Uisce Éireann's Ref: PN26000041519

Planning Ref: VA29N.324276

Development Location: c. 2.27 ha site on the R139, Belmayne, Clonsaugh, Dublin 17

Strategic Infrastructure Development - The construction of a 110 kV / 38 MV electrical substation and associated works including provision of new site entrance and internal access.

Figure 3-1: Existing wastewater infrastructure (source: Uisce Éireann)

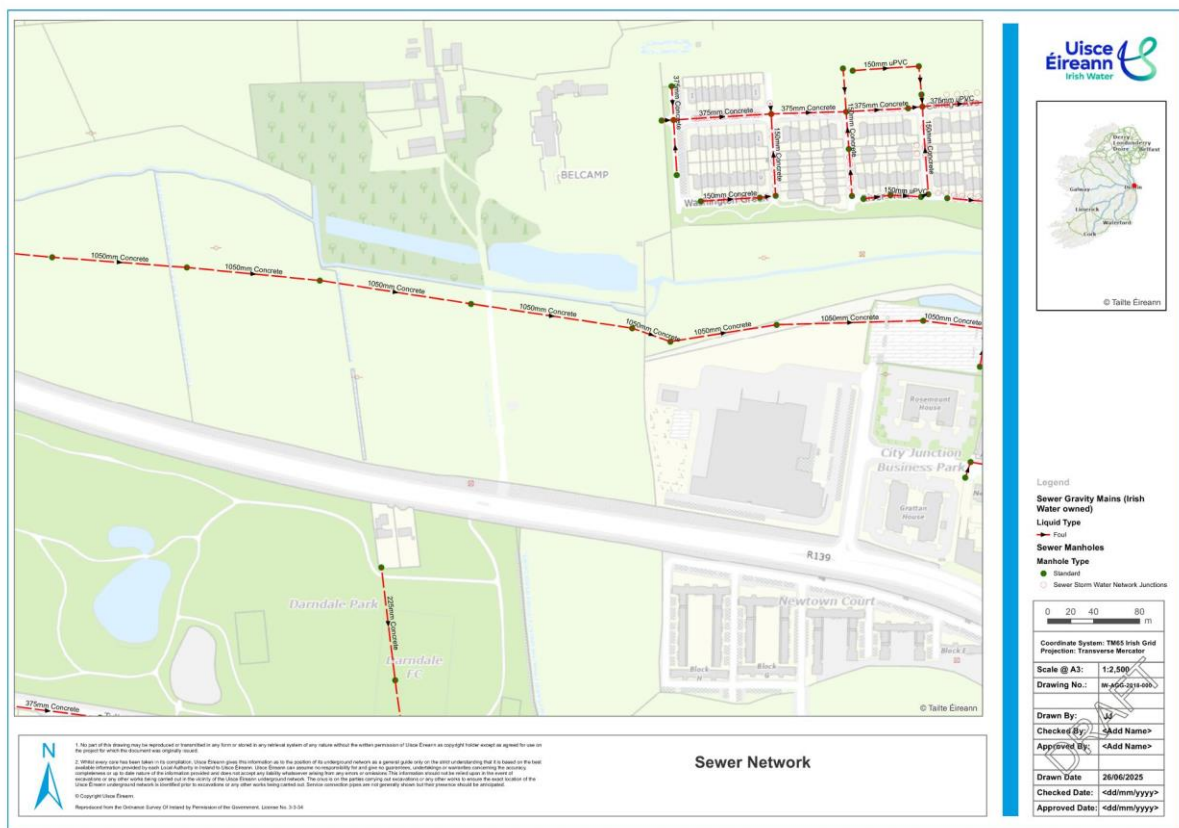
There is a significant 1050mm sewer running within the northern portion of the site The proposed stonewall is setback 10m from this asset.

Uisce Éireann does not permit build over of its assets and the separation distances as per Uisce Éireann's Standards Codes and Practices must be achieved. Uisce Éireann requires that the applicant engages with Uisce Éireann's Diversions team to assess feasibility of the build over and to ensure adequate protection of Uisce Éireann Assets during construction.

1. The applicant shall enter into a connection agreement with Uisce Éireann prior to the commencement of the development and adhere to the standards and conditions set out in that agreement.
2. The applicant must lodge a build over enquiry and obtain a Confirmation to Build Over from Uisce Éireann's Diversion team prior to the commencement of the development.

Figure 4-1: Existing water infrastructure (source: Uisce Éireann)

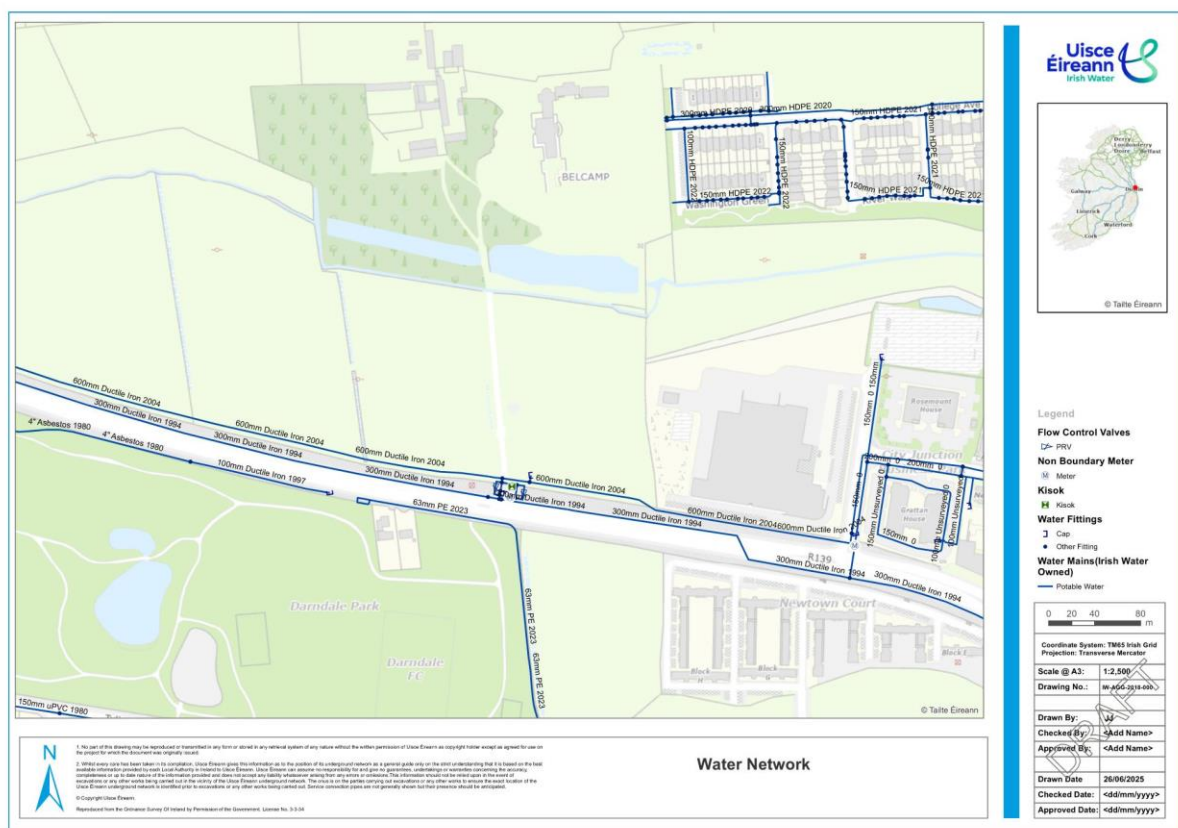
There is an existing 600mm water main within the southern boundary of the site and another 300mm within the road reserve of the R139. The proposed stonewall is setback 5m from this asset. The upgrade works including the replace the asphalt on the existing access road and widening of the existing entrance have the potential to impact these assets.
